RR359 Emma Glass

© Crown copyright and database rights 2025.
Ordnance Survey AC0000808122

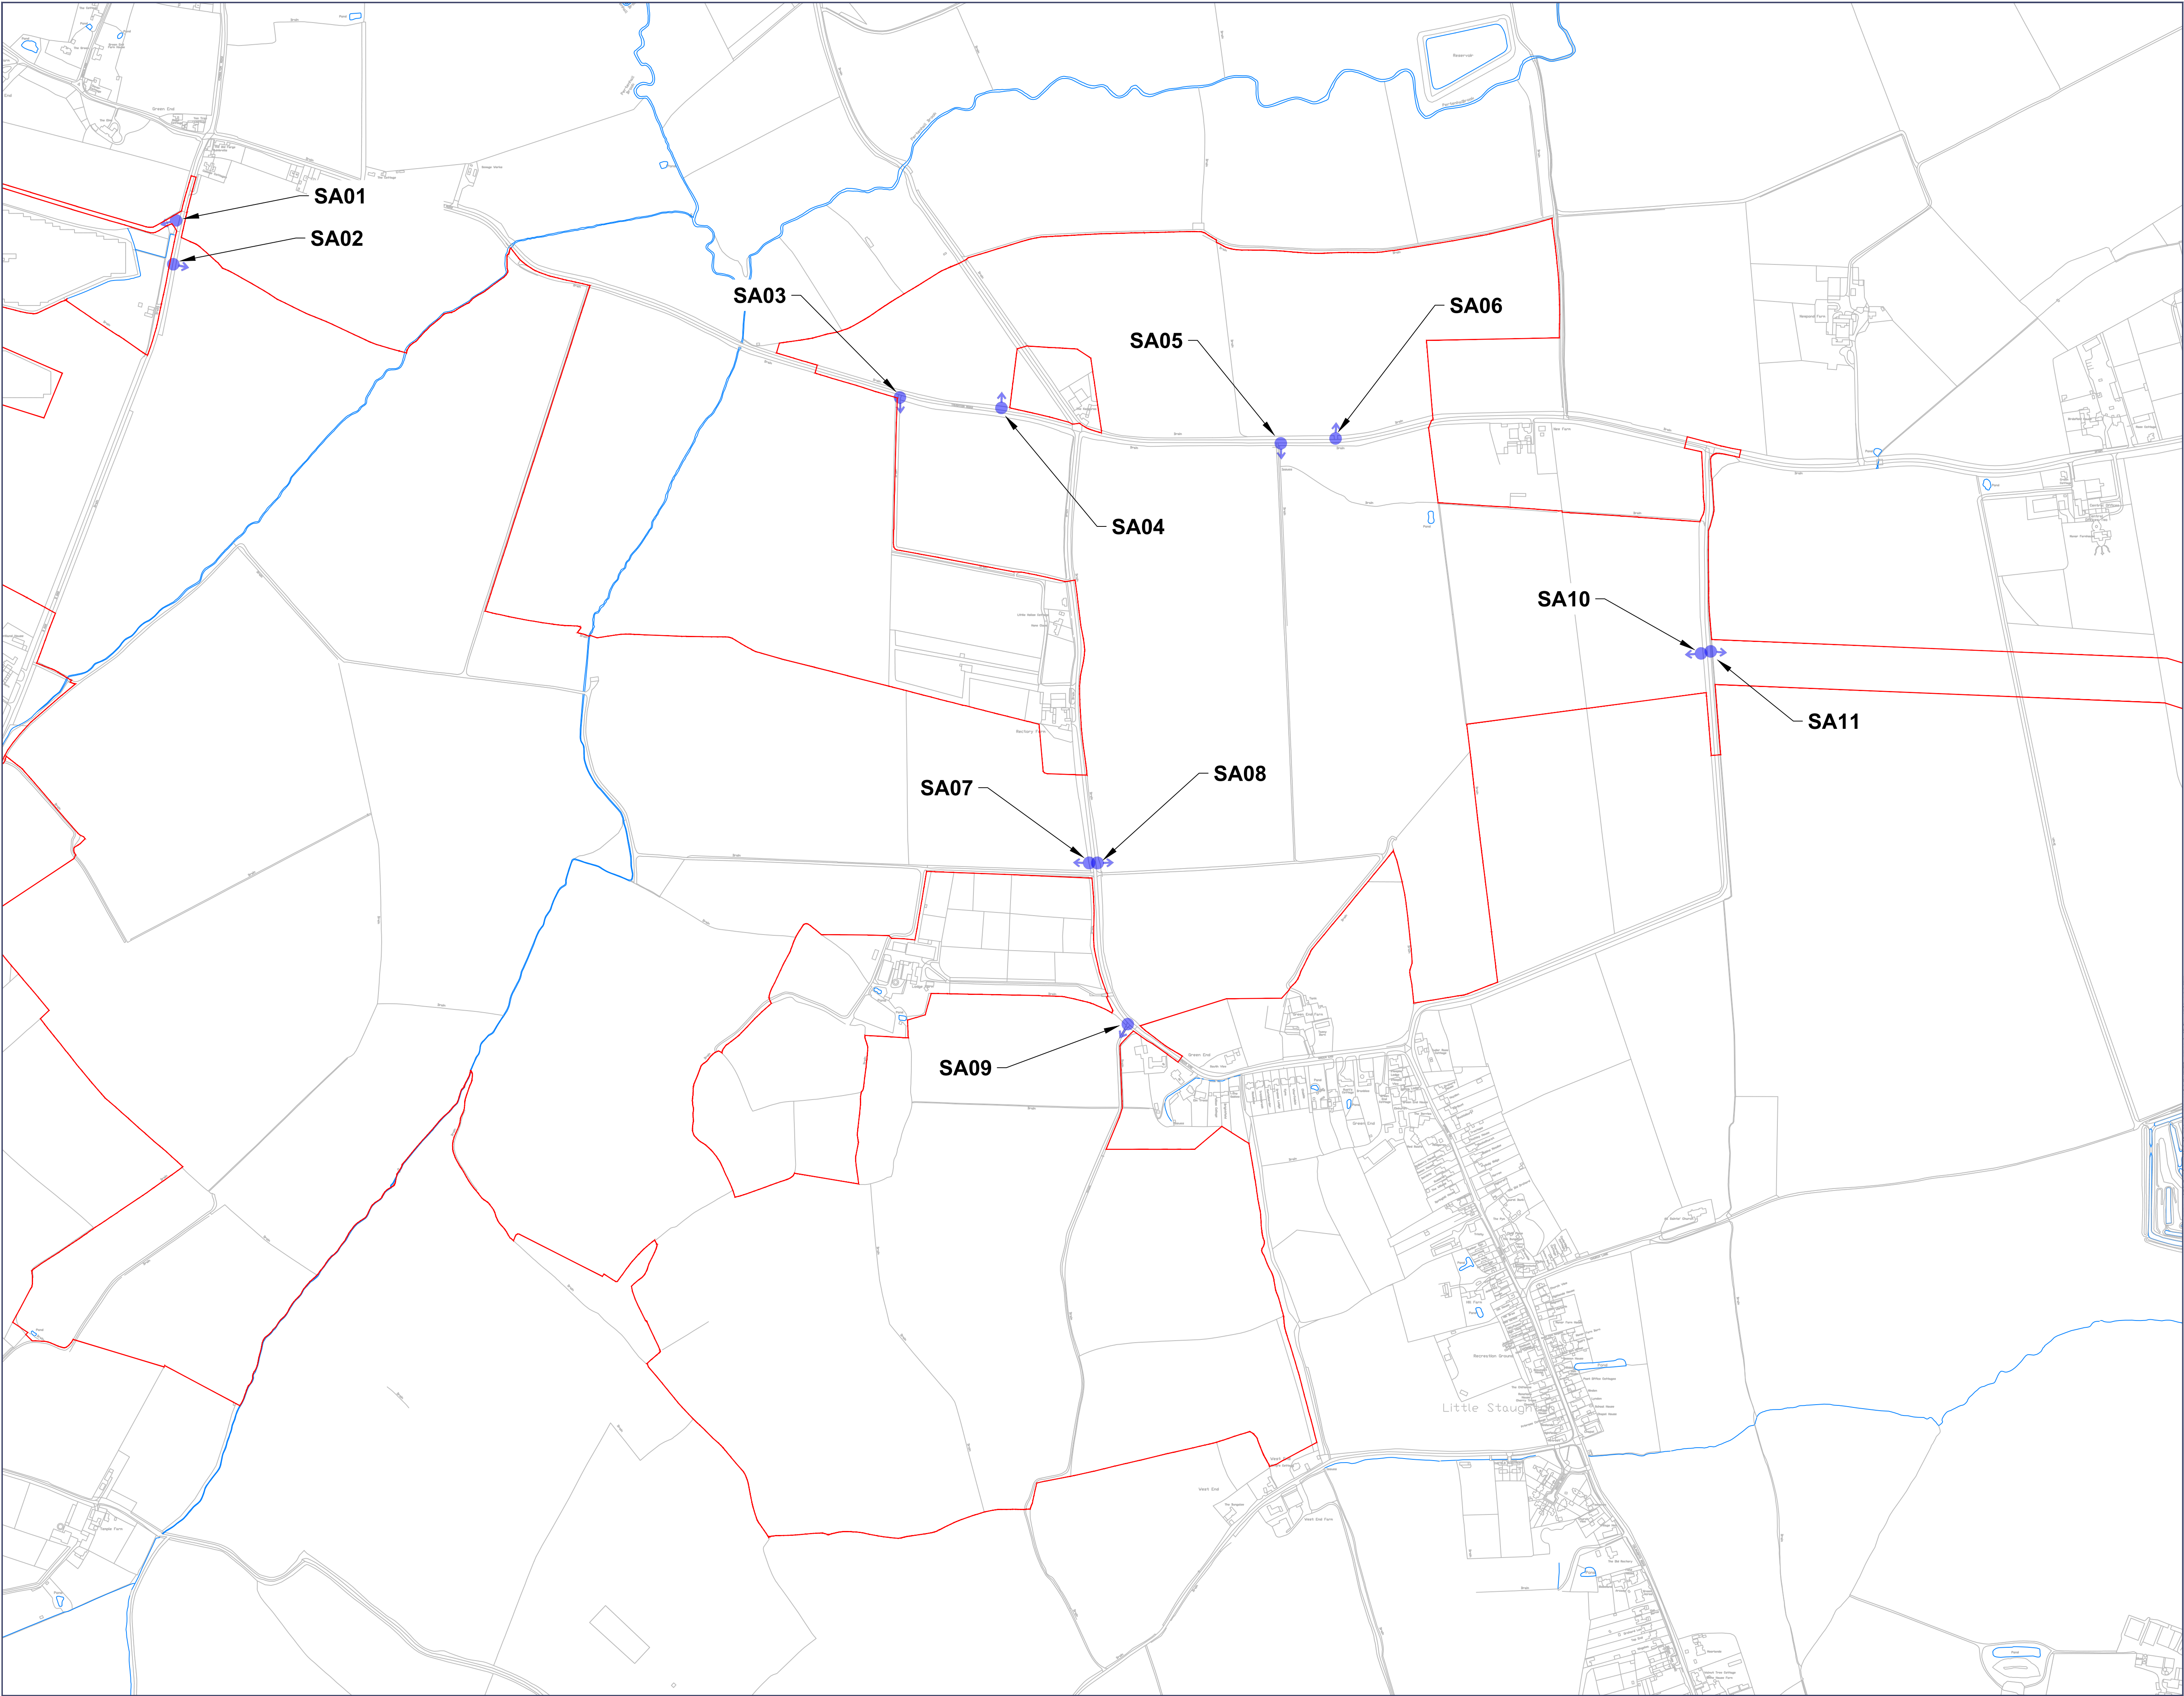
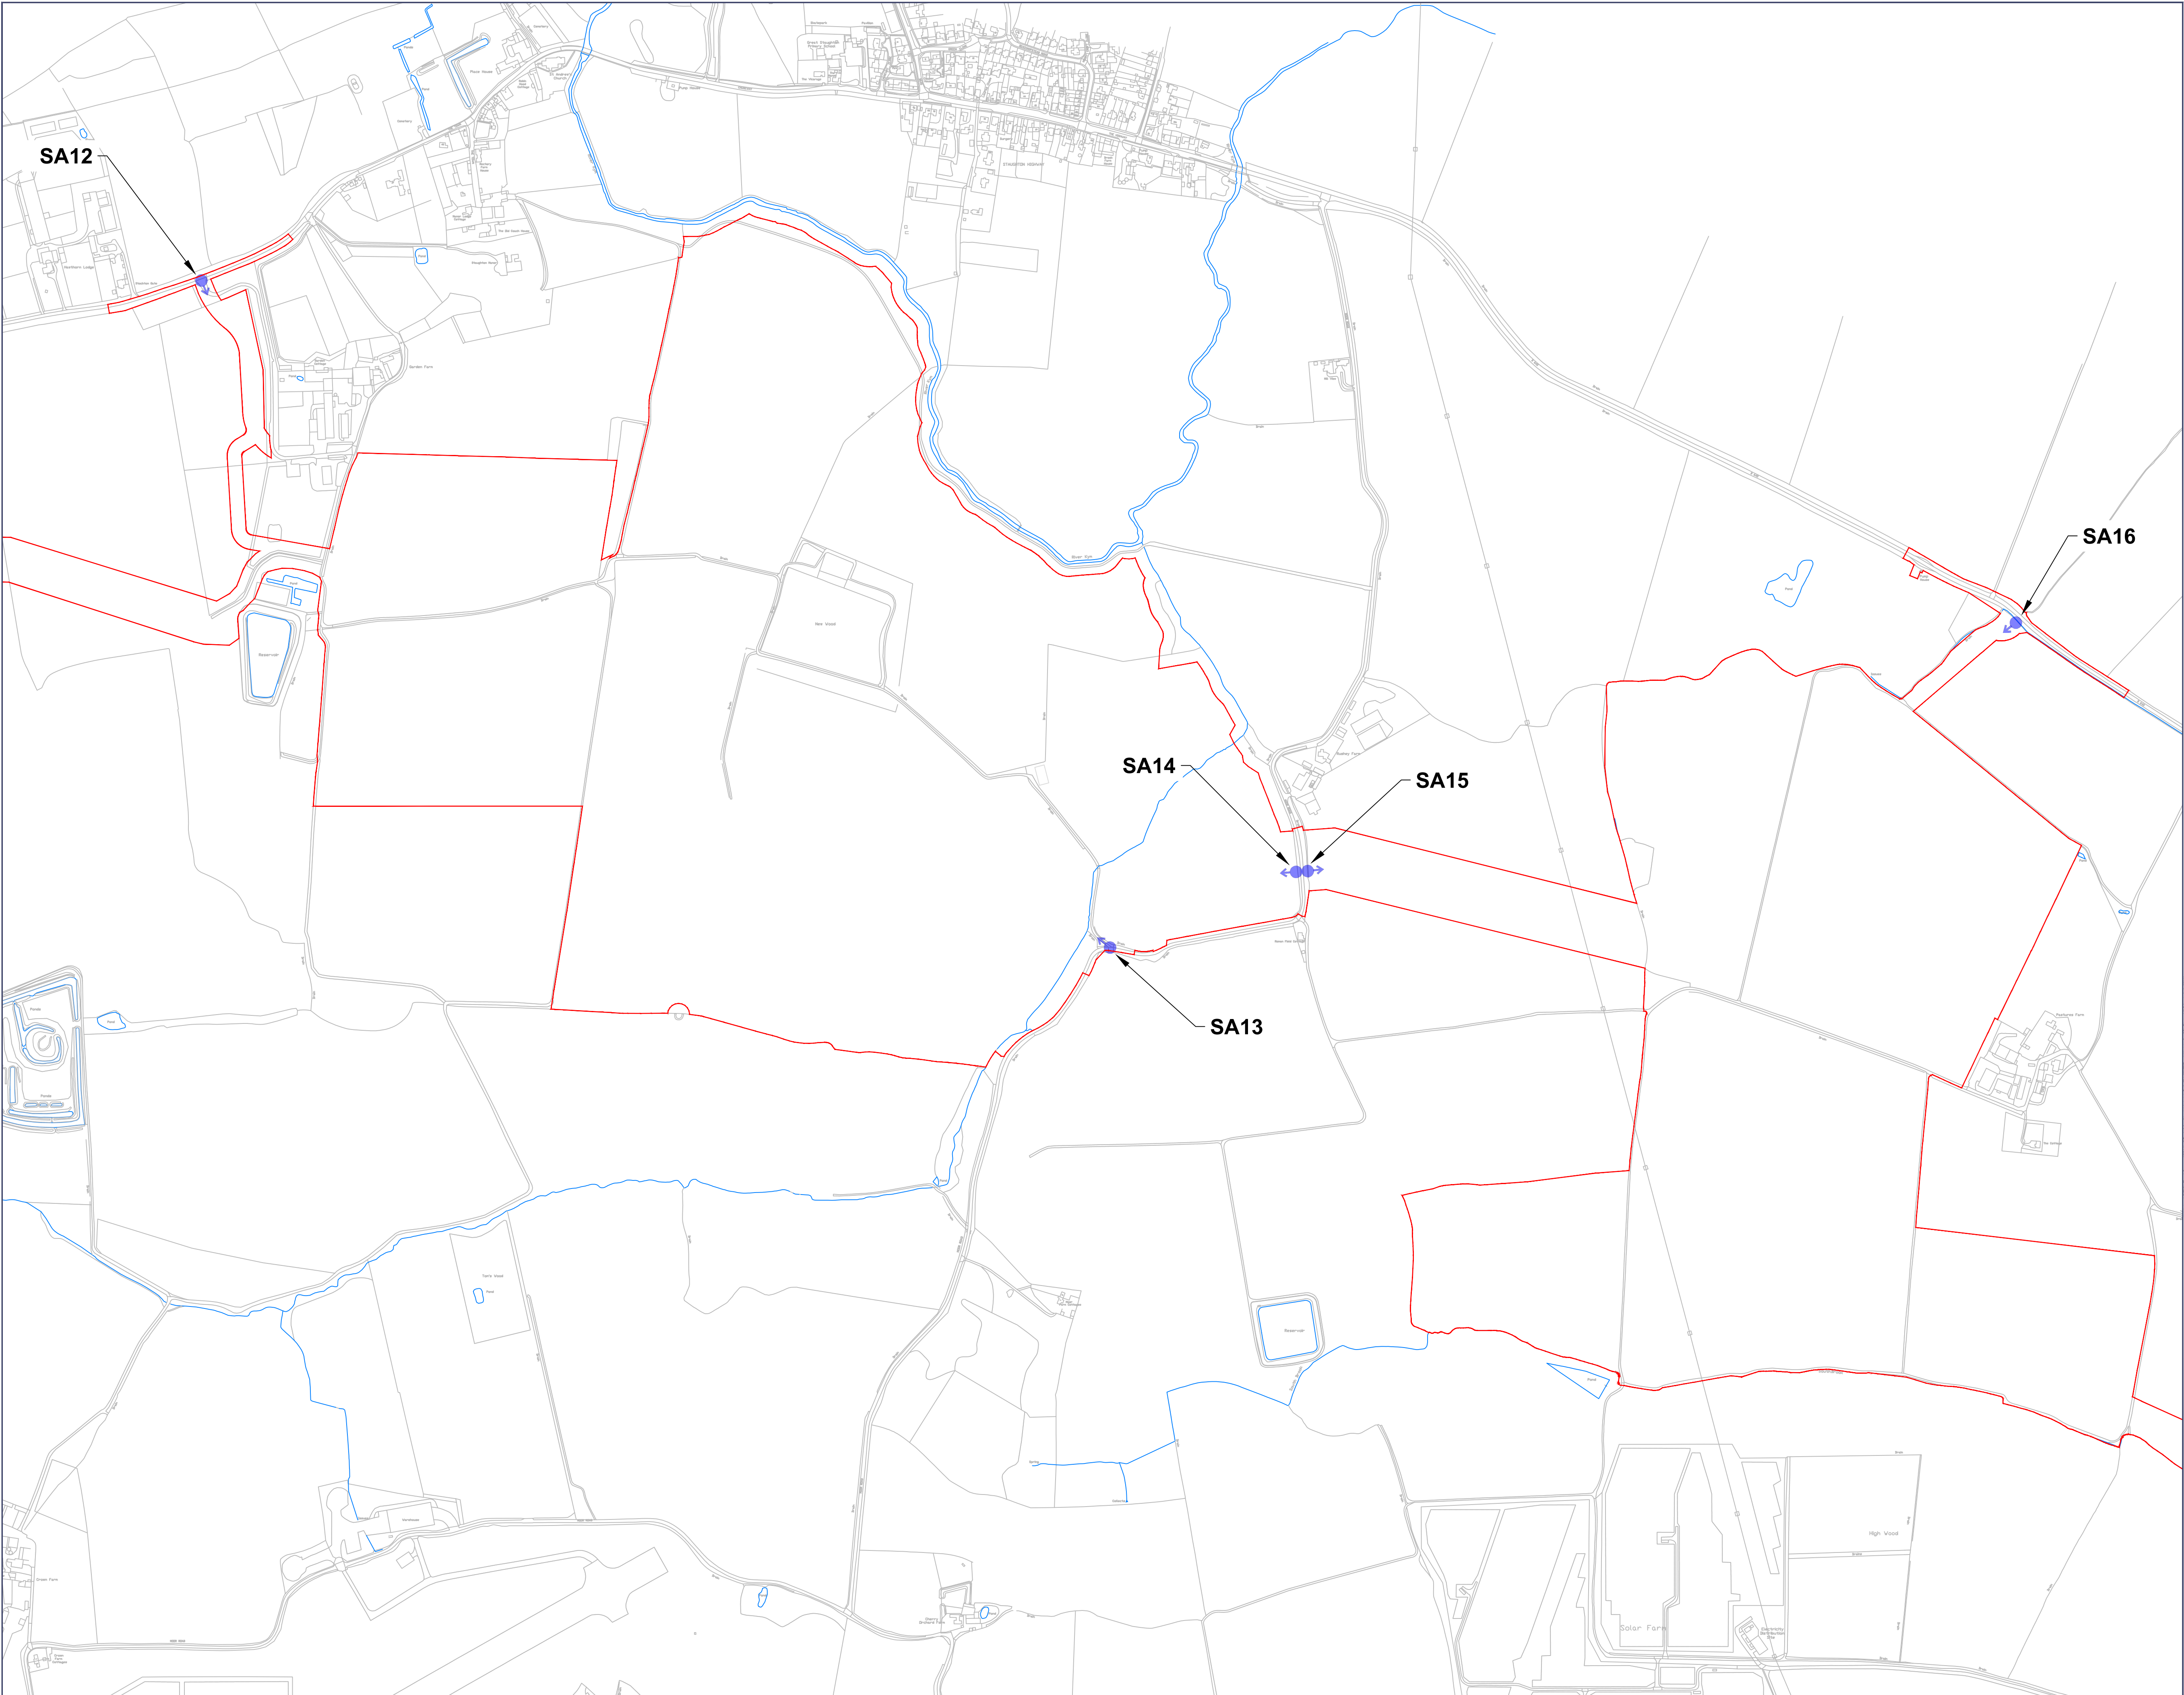
On the original plans, the entrance to Site D compound was through tracks after Hail Weston and before the bends, towards R A Hamilton Farm. This alternative would significantly reduce risk and allow for controlled access with traffic lights.

Why has this safer access route not been pursued, and will it be reconsidered?
